Response to Sizewell C DCO Issue-specific hearing 6 (ISH6) Coastal geomorphology meeting on the 14th July 2021.

Author: Nick Scarr, Interested Party number 20025524

This document is a response to the issue specific geomorphology hearing (ISH6). This paper relates primarily to the agenda item referring to the Sizewell-Dunwich banks and their relevance to the flood risk and shoreline change assessments submitted by the Applicant.

The Sizewell-Dunwich Banks. The purple arrows mark 26700N— to the north of which the crest height of Dunwich bank is lowering. Chart base from BEEMS Technical Report TR500 'Sizewell-Dunwich Bank Morphology and Variability'. Page 14. Markup my addition.

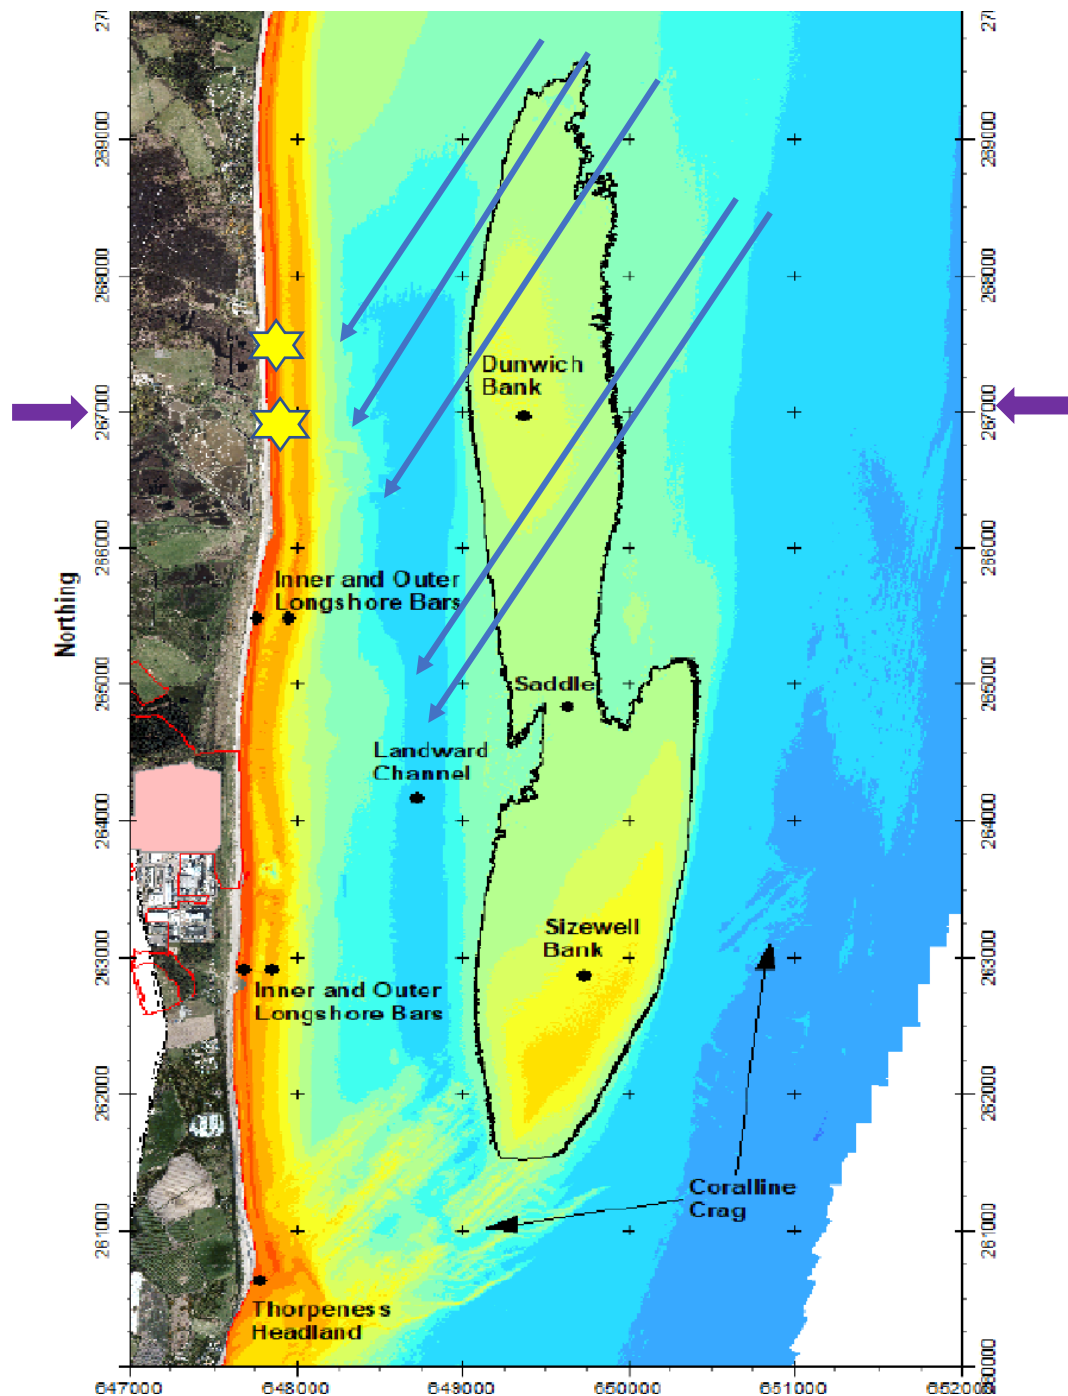
The Marine Management Association has stated that the Dunwich bank has dropped 2m in the last 10 years. See end of document map of Dunwich banks

It is obviously unsupportable to consider offshore geomorphology at Sizewell as unchanging. Also, what is ‘present bathymetry’ – what date was this ‘present bathymetry’ decided – what are its constituent parts, does it include the 2m reduction in the Dunwich bank? Why is it logical to focus on ‘present bathymetry’?
